**Drainage Letter
Rock Island Trail
Sand Creek to Constitution
Colorado Springs, Colorado**

Prepared for:
City of Colorado Springs
Parks, Recreation and Cultural Services Department
1401 Recreation Way
Colorado Springs, CO 80905
(719) 385-6951

Kiowa Project No. 16028
SWENT File: STM-REV24-____
EPC Project Number: CDR193

March 7, 2024

<p>ROCK ISLAND TRAIL Sand Creek to Constitution Avenue EXISTING DRAINAGE MAP</p>	<p>Kiowa Proj. No. 16028 TAP M240-162 SubAcct No.20391 Sheet Number <b>EDM-1</b></p>
			<p>No Revisions:</p> <p>Revised:</p> <p>Void:</p>	<p>Designer: RNW Detailer: RNW Date: 3/7/2024</p>

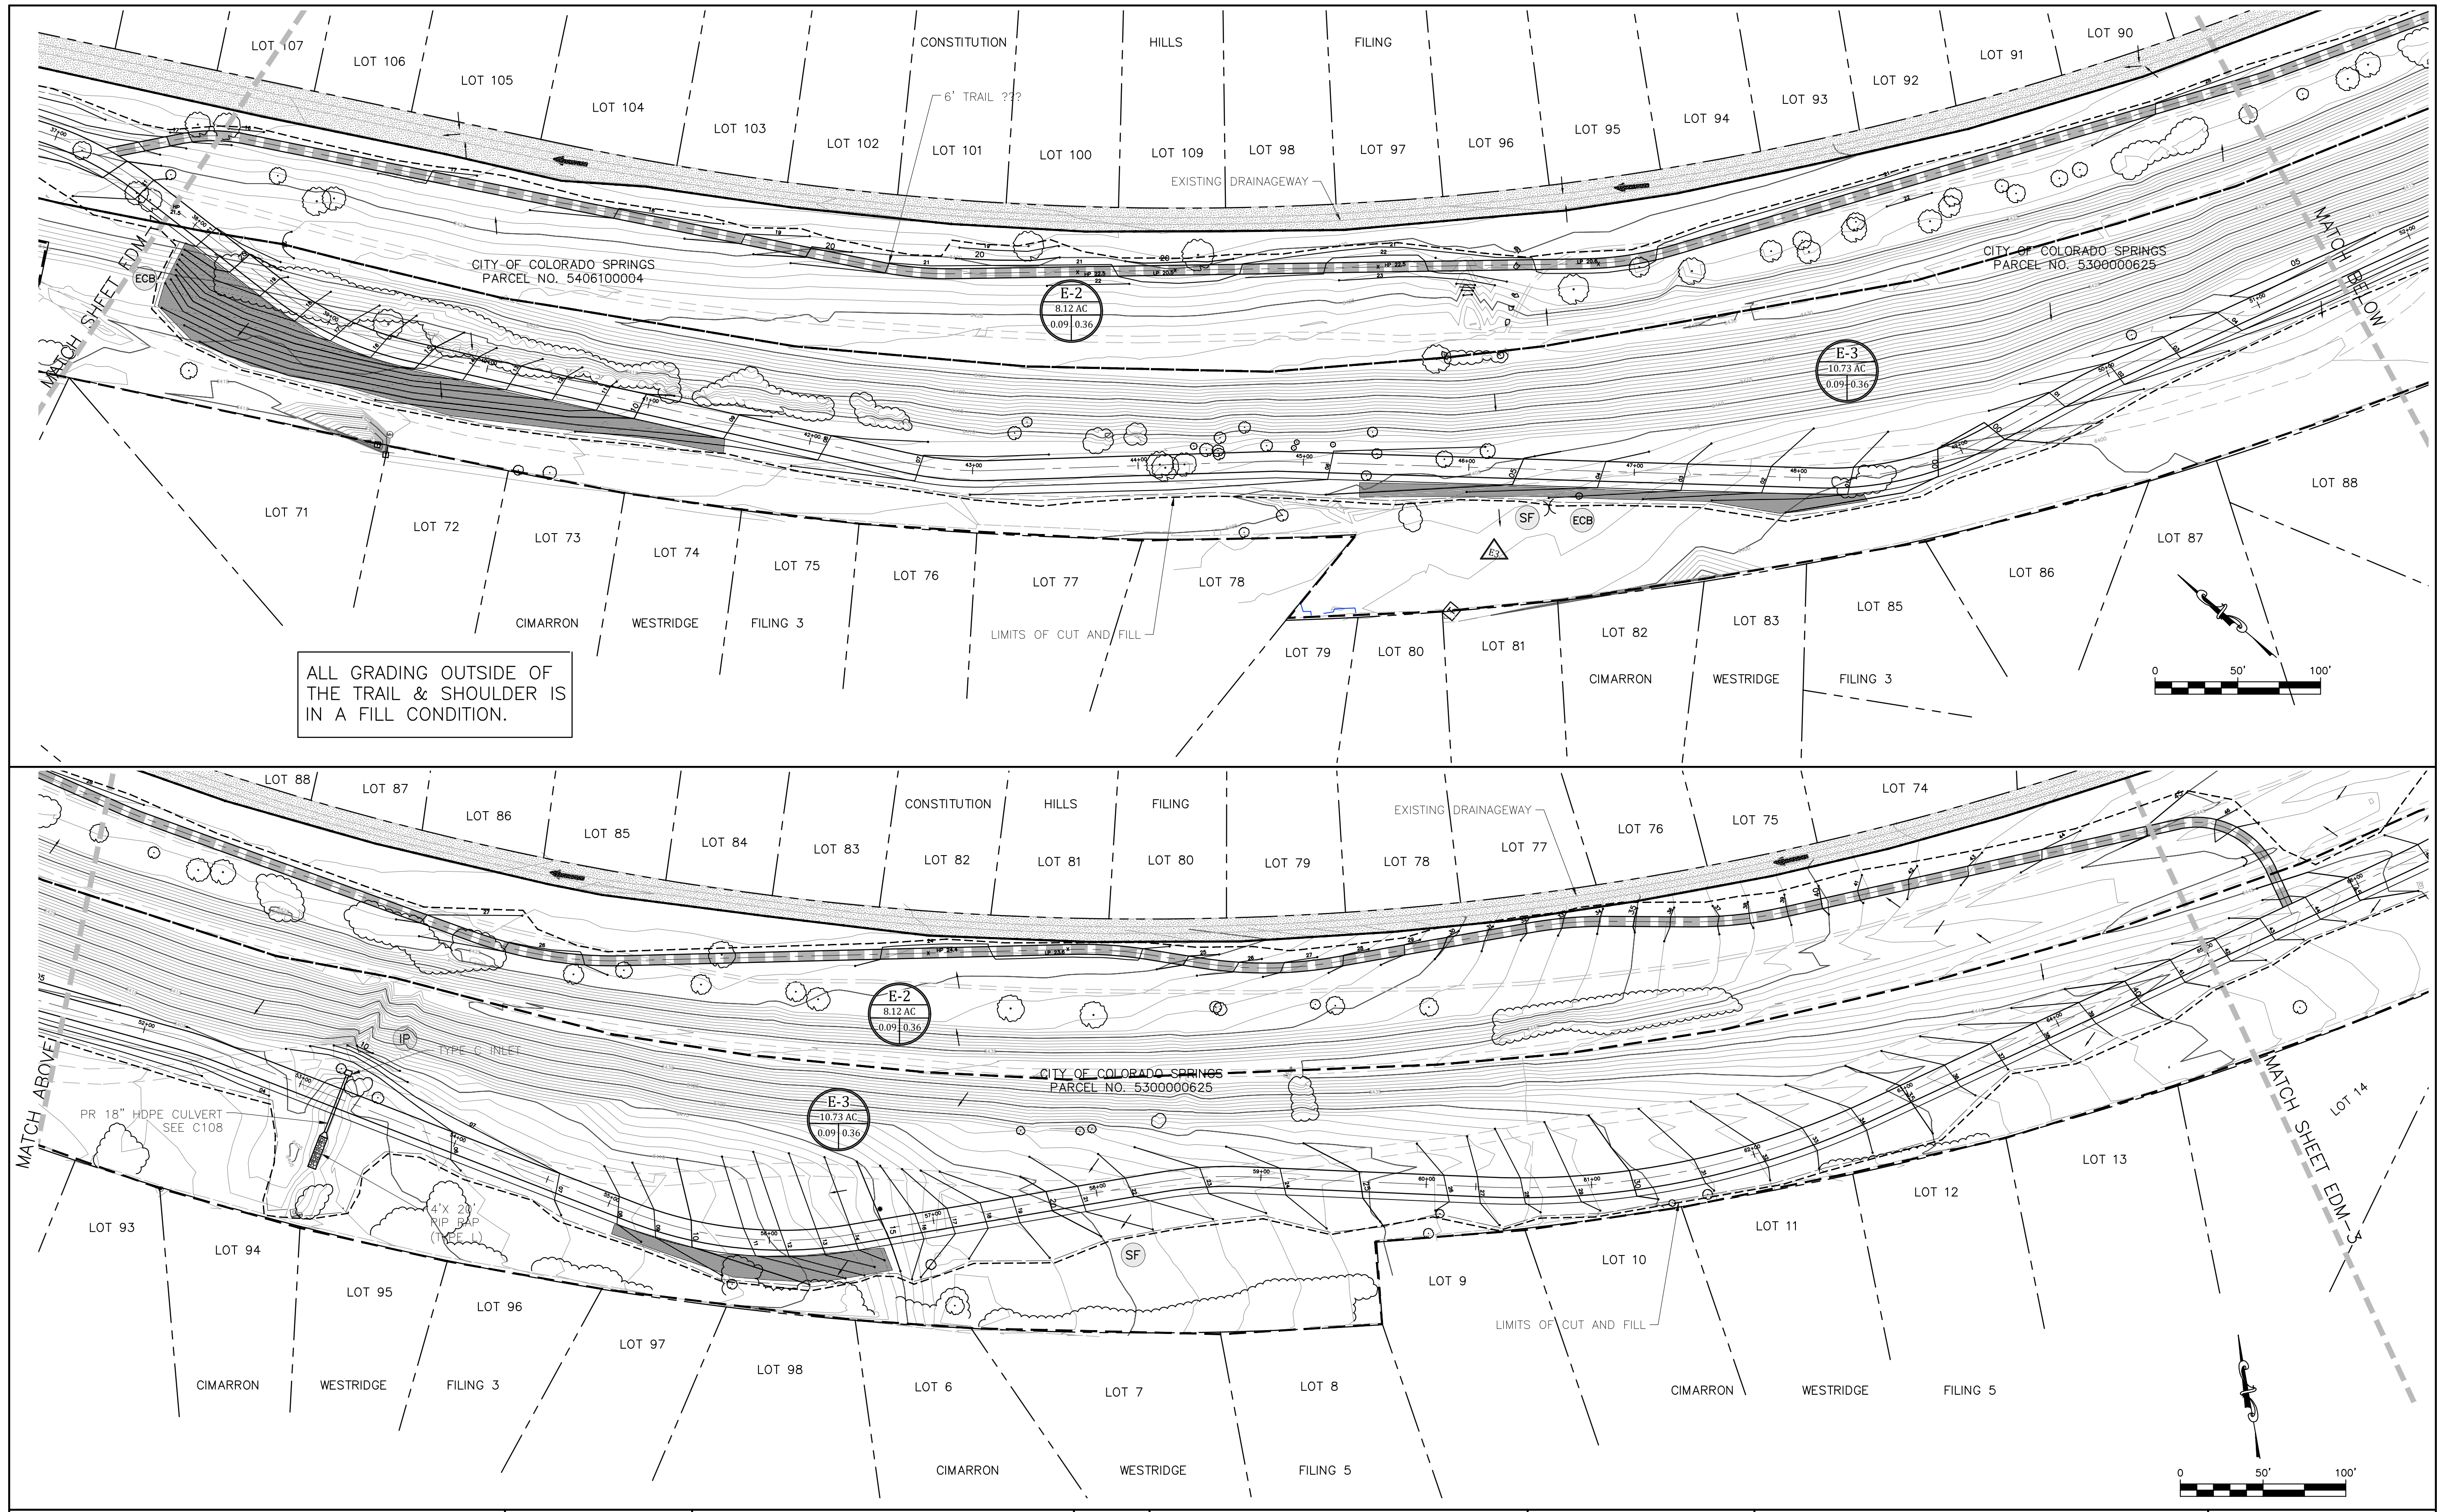
It appears that there is a proposed culvert, and a rip rap at the basin 6. Please discuss it in the proposed drainage patterns.

Discuss the locations where the flow will not sheet flow (ie the proposed culvert) and discuss if that will cause erosion or downstream impacts.

The existing and proposed drainage map was not provided, so this statement cannot be verified. Also, the total disturbed area is 4.48 acres. Given this, it is unclear how the proposed drainage runoff is the same as the historical runoff.

Calculations of proposed inlet and rip rap are required.
